Our Ref: R/2019/22/B
File No: 2021/128240
Your Ref: SSD 10382

Response to Submissions – Student Accommodation (SSD-10382) – 90-102 Regent Street, Redfern

Thank you for your correspondence dated 4 March 2021 requesting for the City of Sydney Council (“the City”) to comment of the Response to Submissions (RTS) for the abovementioned application for student accommodation at 90-102 Regent Street, Redfern.

1 DA PLANT PLAN  
1:200

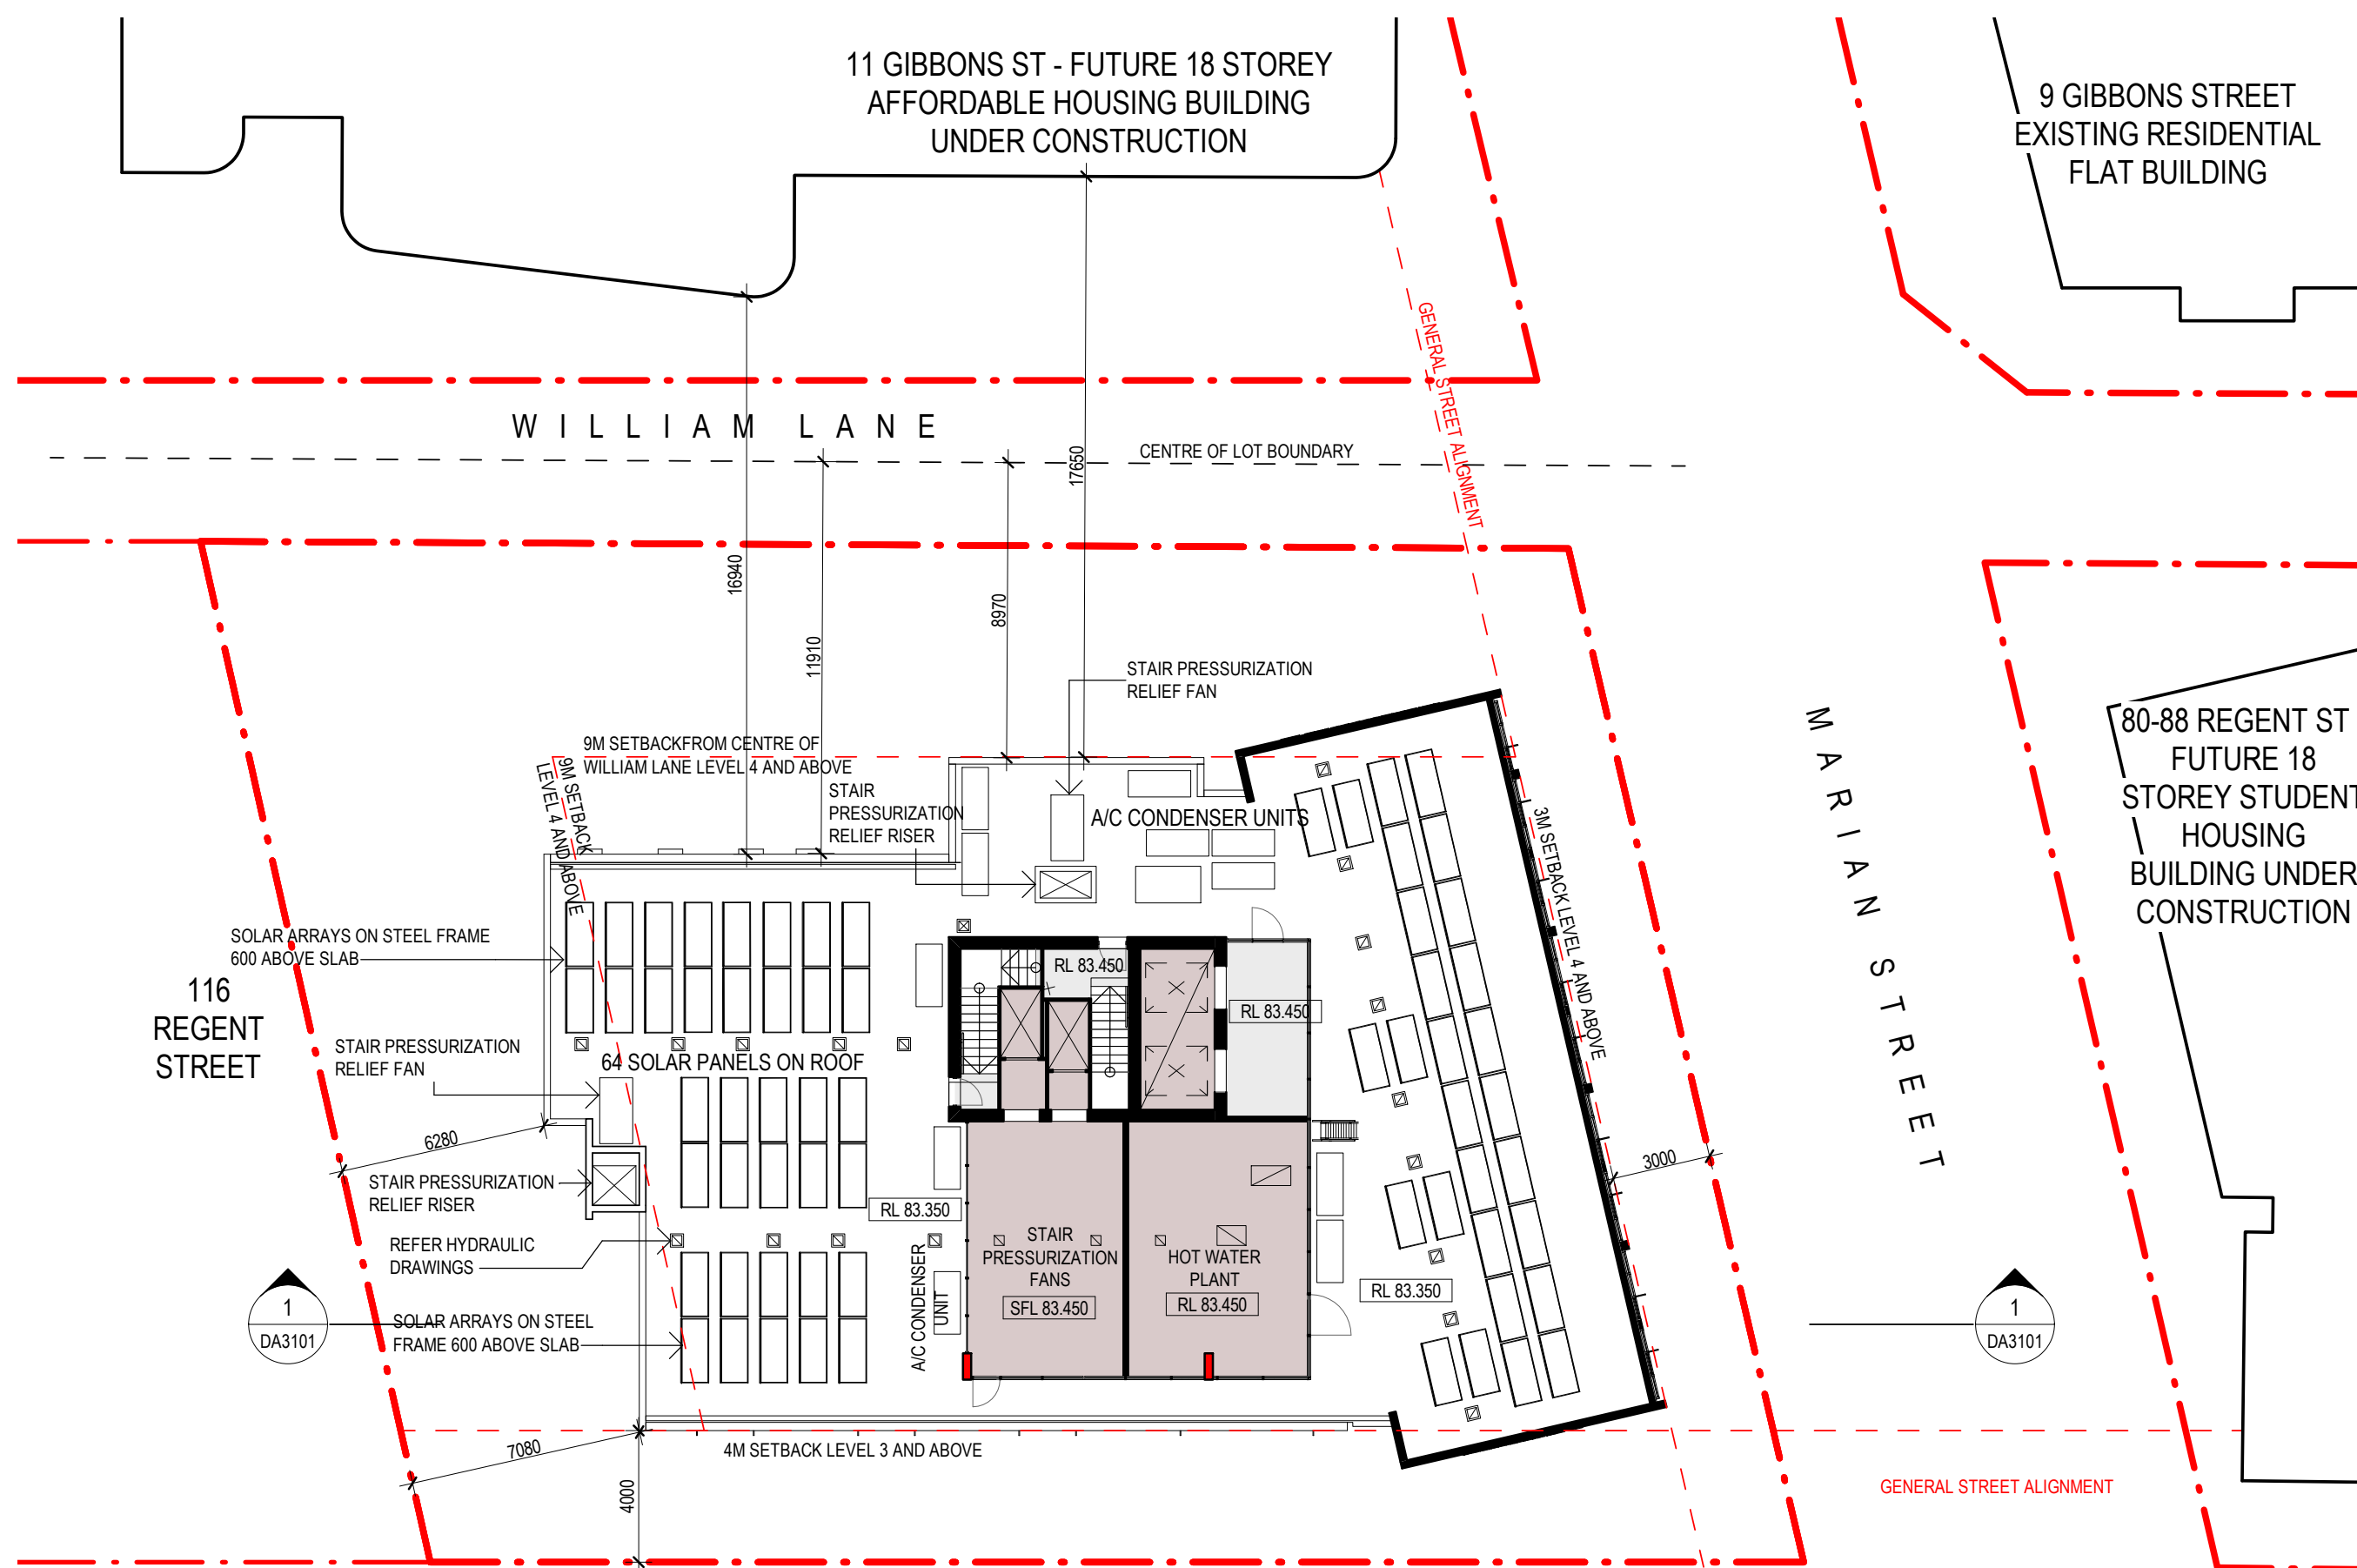
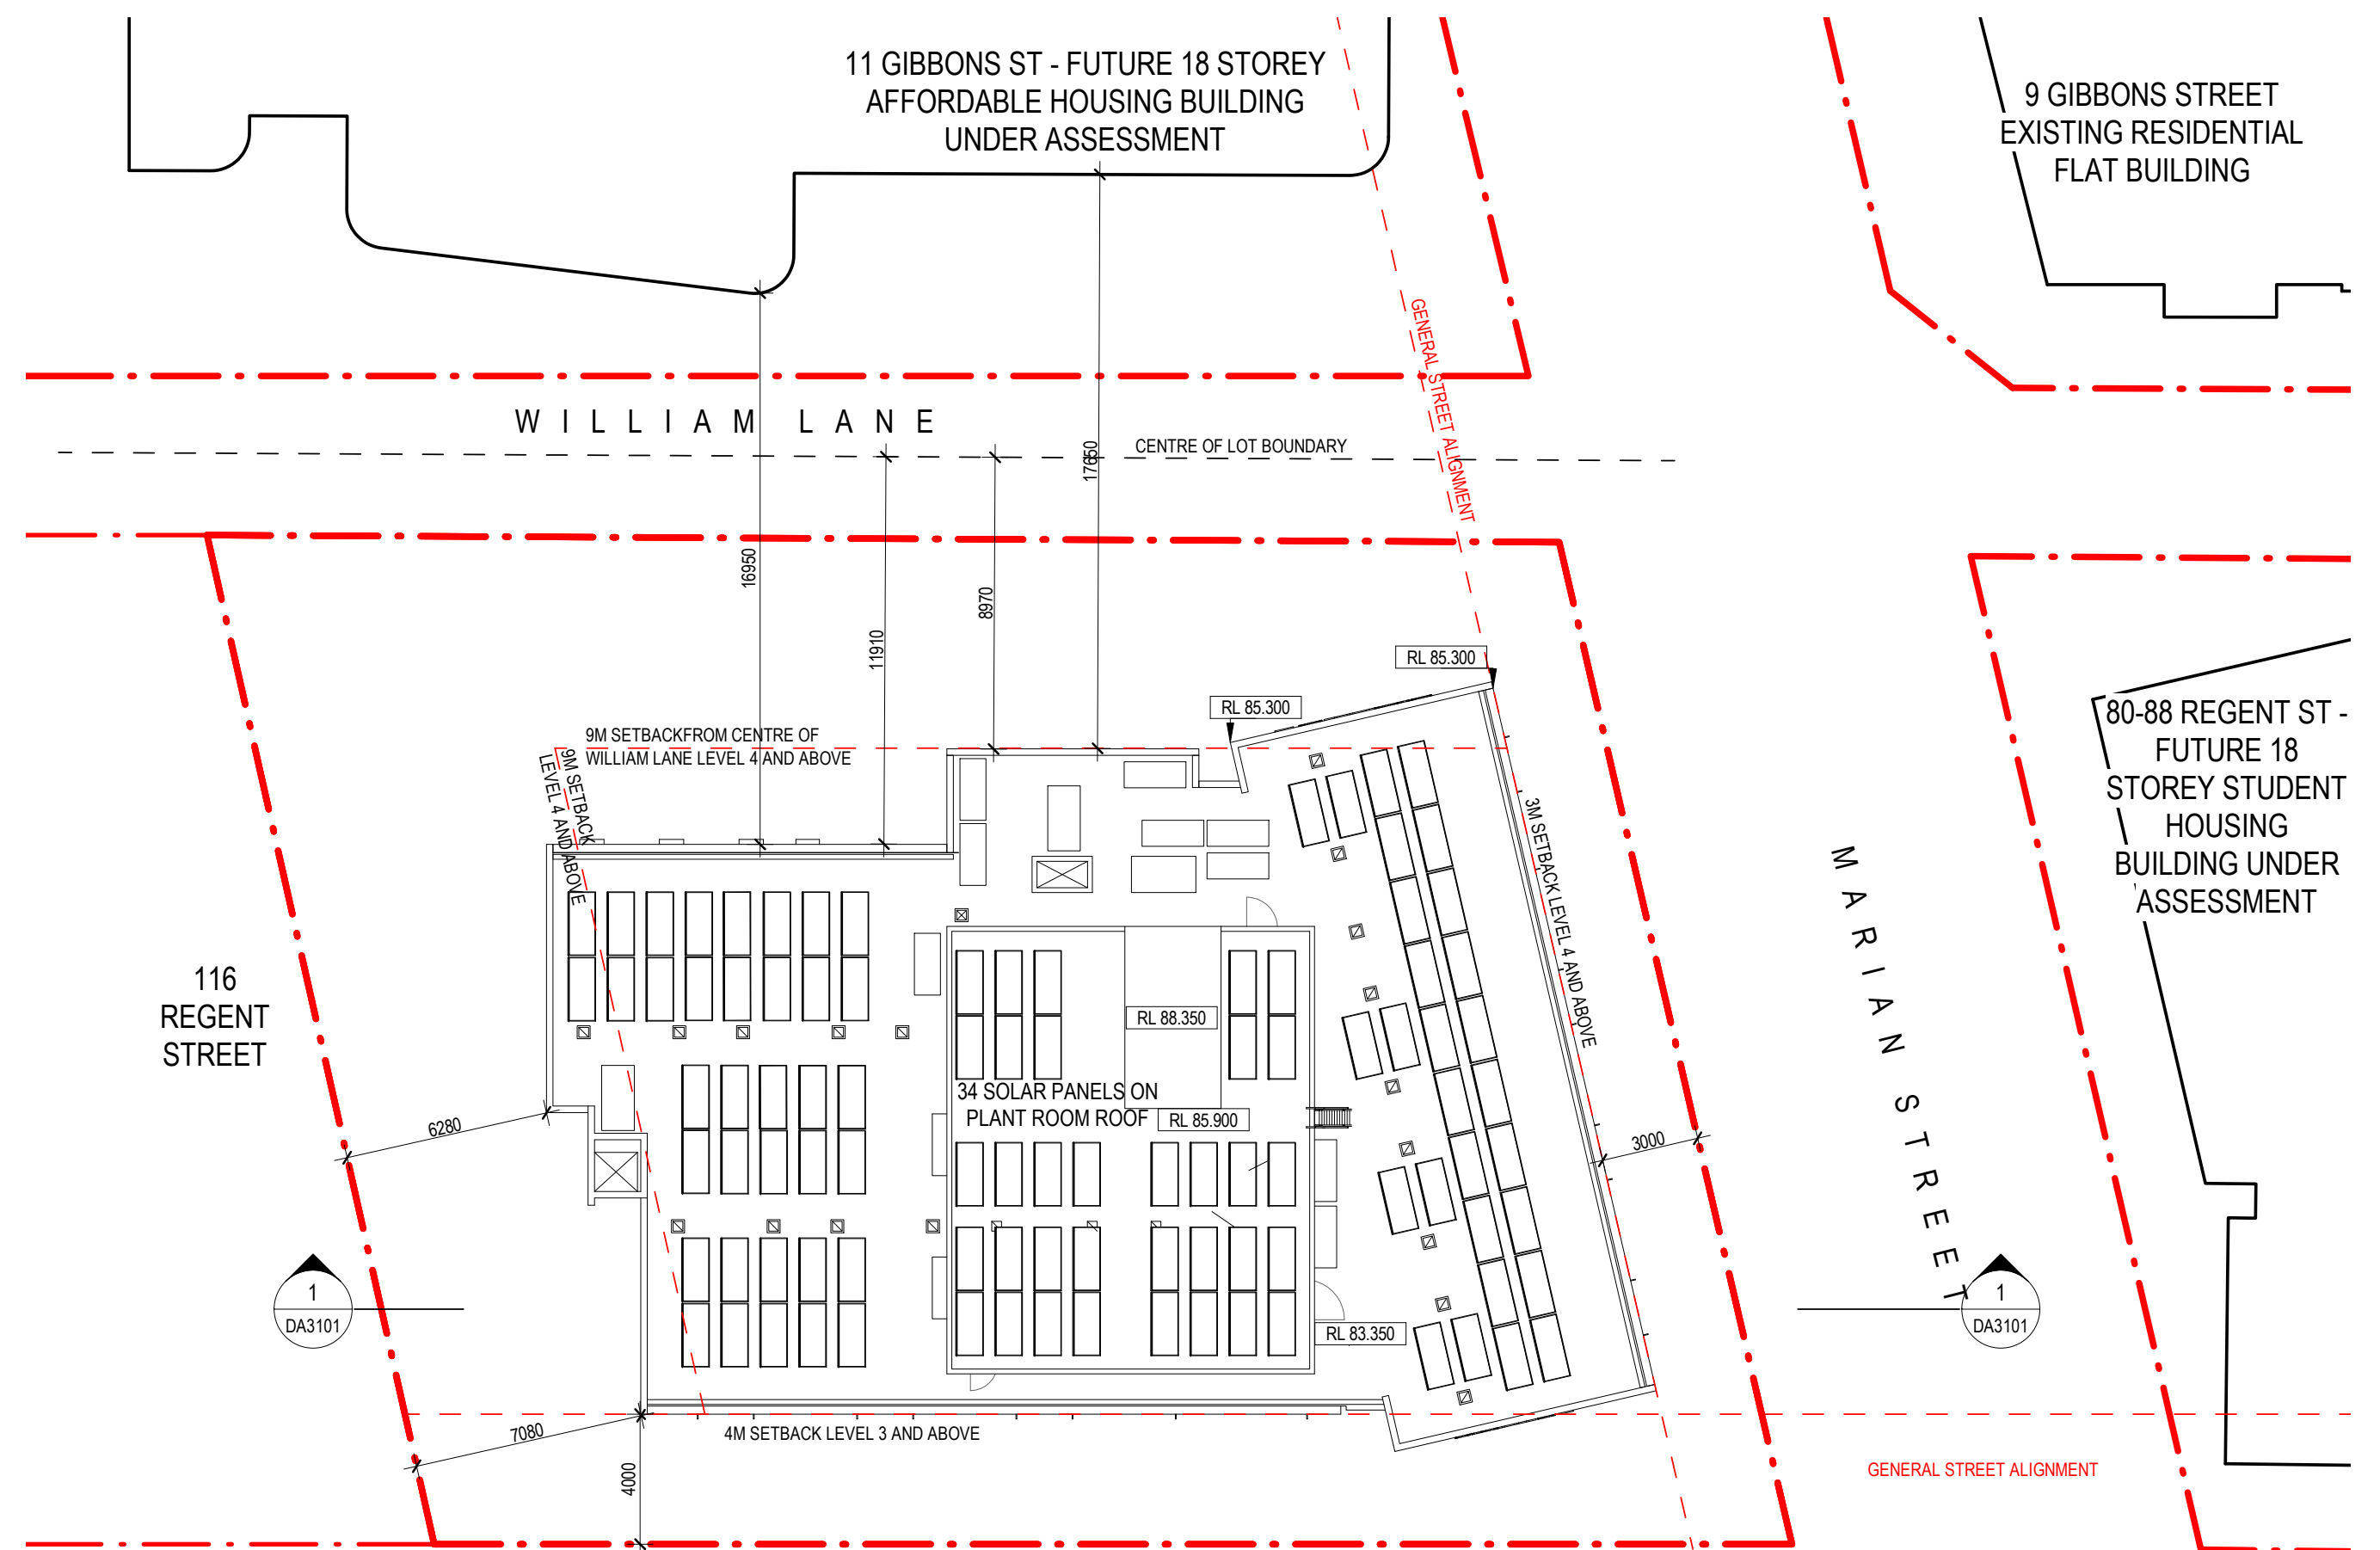
Further, the development provides plant and services on the roof of the building. To optimise the building design, the City strongly recommends that the parapet of the building be raised to align with the height of the lift overrun. This would improve the visual appearance of the tower element in obscuring the visual clutter resulted from roof top plant. The raising of the parapet must comply with the maximum height control.
